CITY OF ALBUQUERQUE

July 14, 2015

**Re: A.I.S. Retail
Grading and Drainage Plan (H13D106)
Engineer's Stamp Date, 7-9-15, 7-7-15 & 6-25-15 (Sheet C1, C2 & C3)**

A.I.S. RETAIL SITE UTILITY PLAN			
MARK GOODWIN & ASSOCIATES, P.A. CONSULTING ENGINEERS			
P.O. BOX 90606 ALBUQUERQUE, NEW MEXICO 87199 (505)828-2200, FAX (505)797-9539			
Designed: KMK	Drawn: KMK	Checked: DMG	Sheet C3 of 4
Scale: SEE SCALE	Date: 11/30/14	Job: A12041

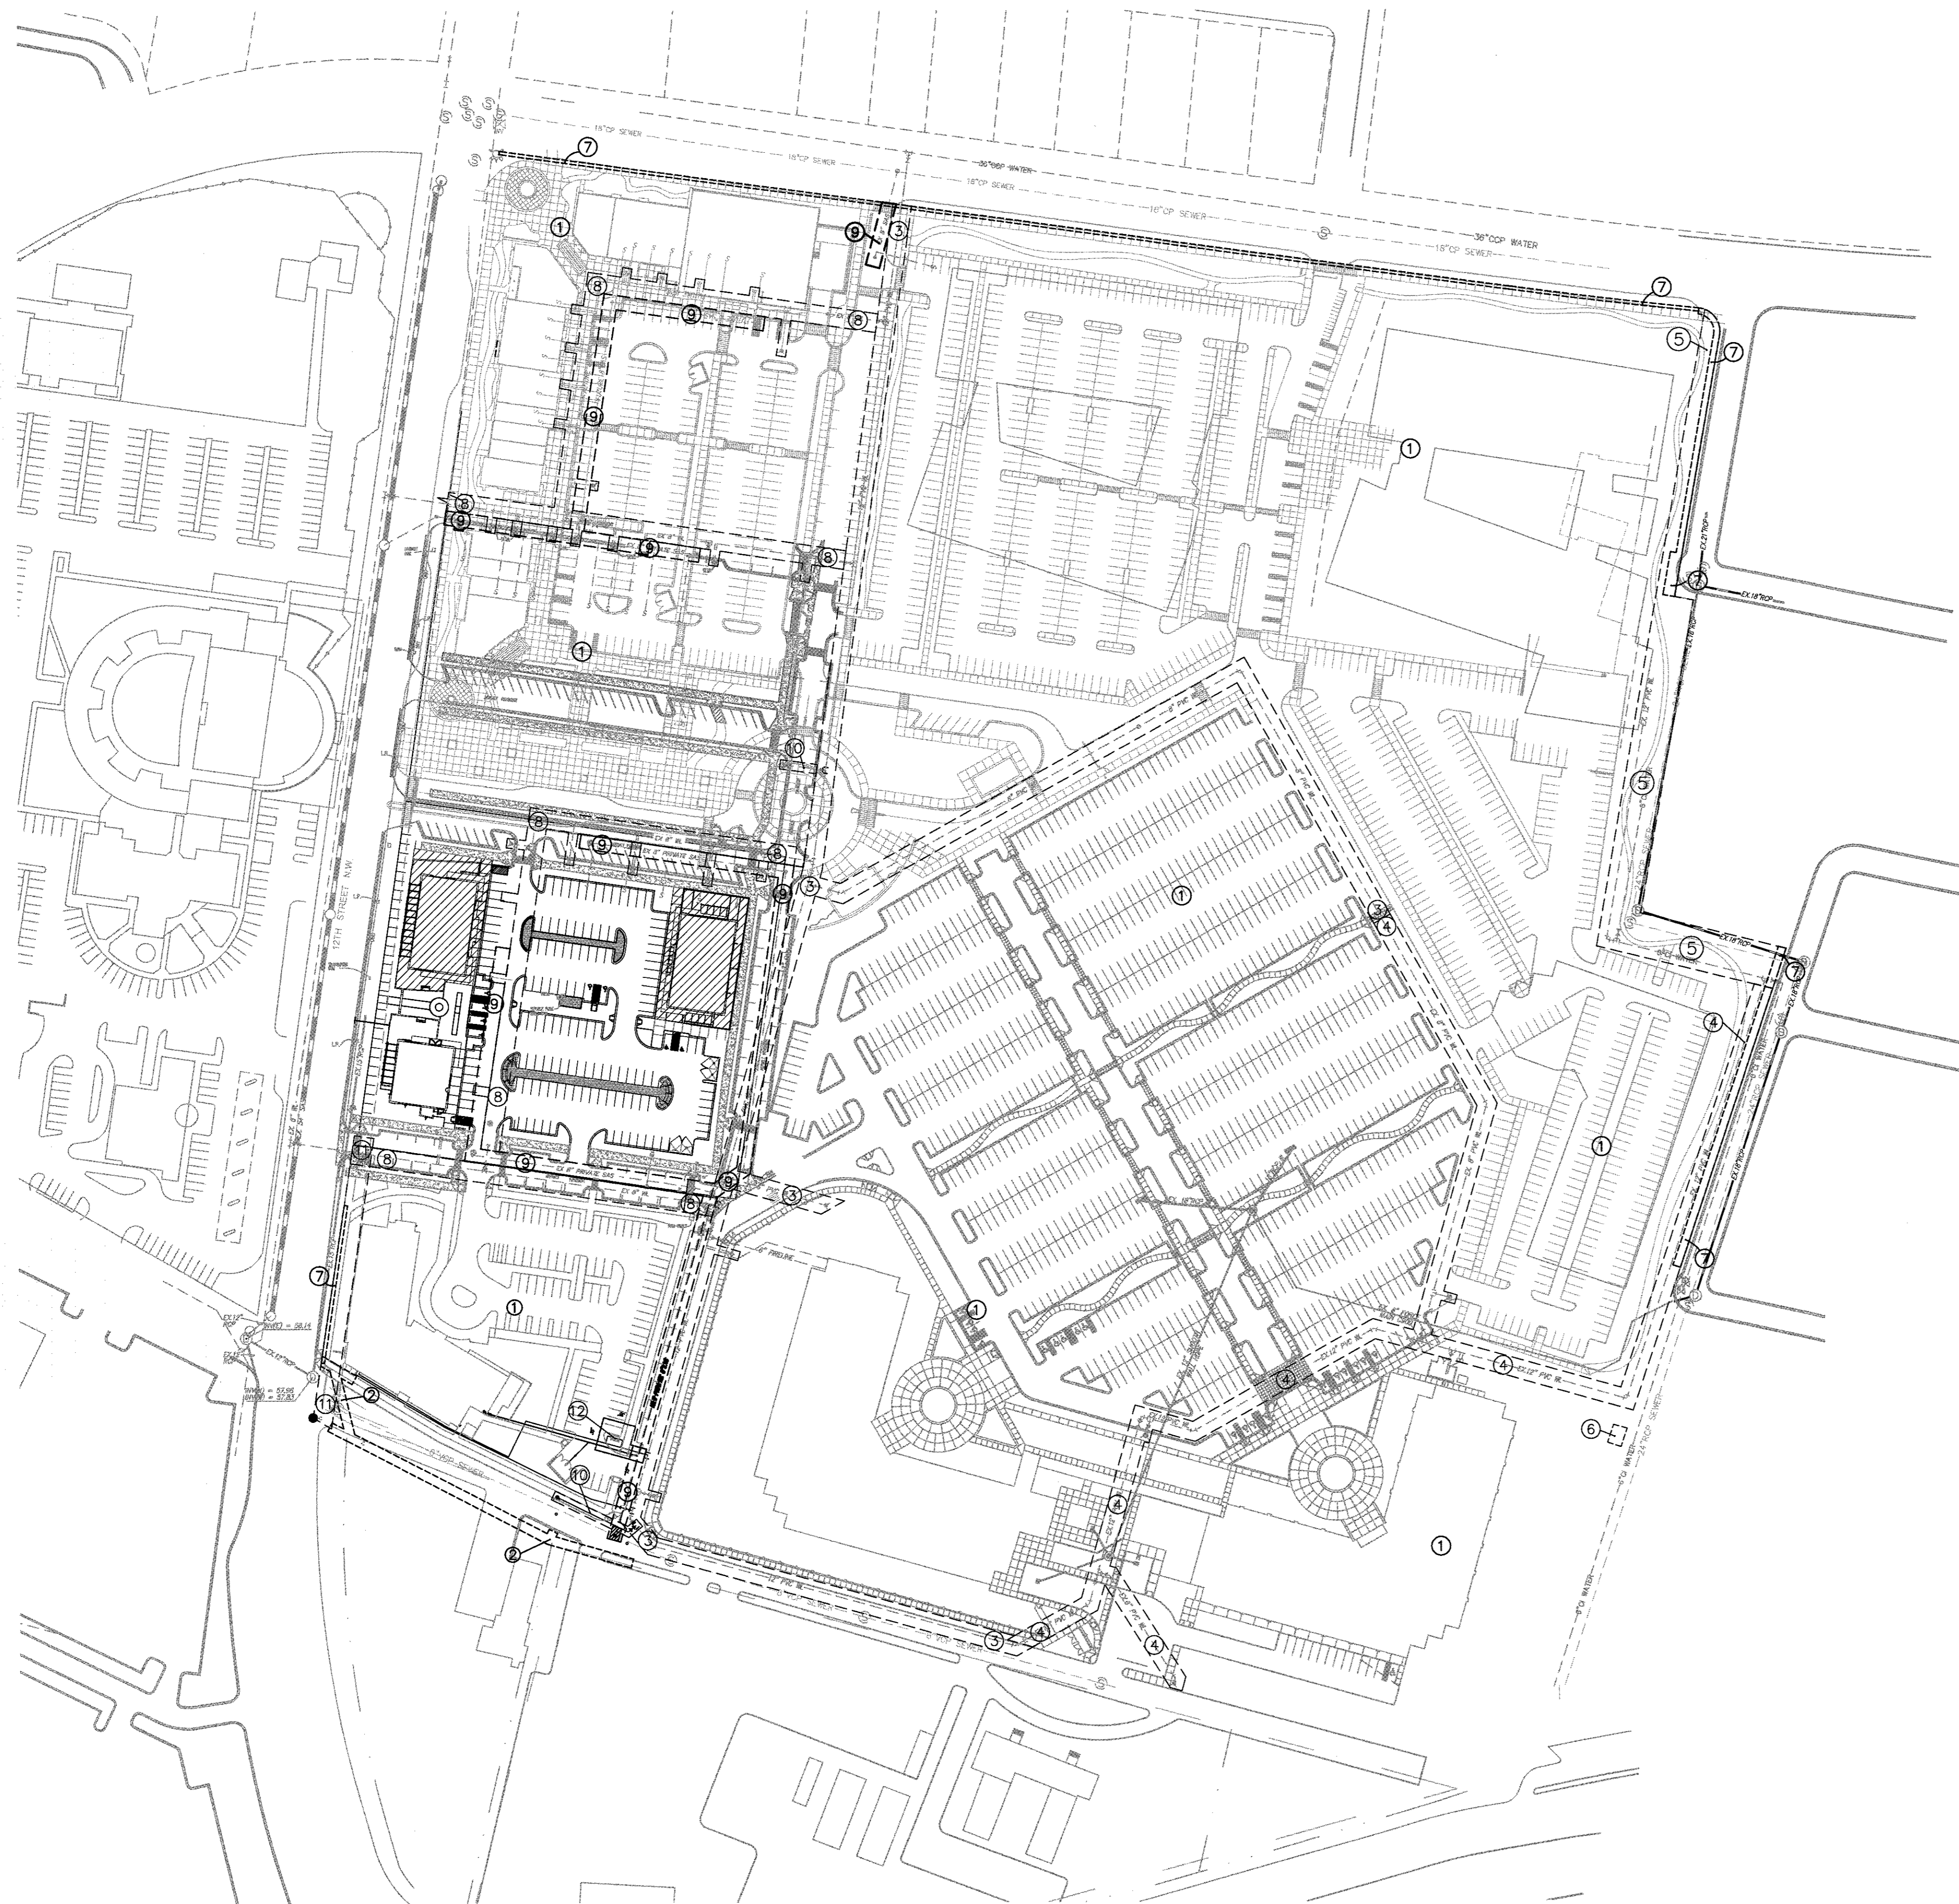
- Please correct the force main line size on sheet C3 of 3.
- Show existing contours. Provide contour elevations on sheet C2 of 3.
- Who will be maintaining the storm drain system?
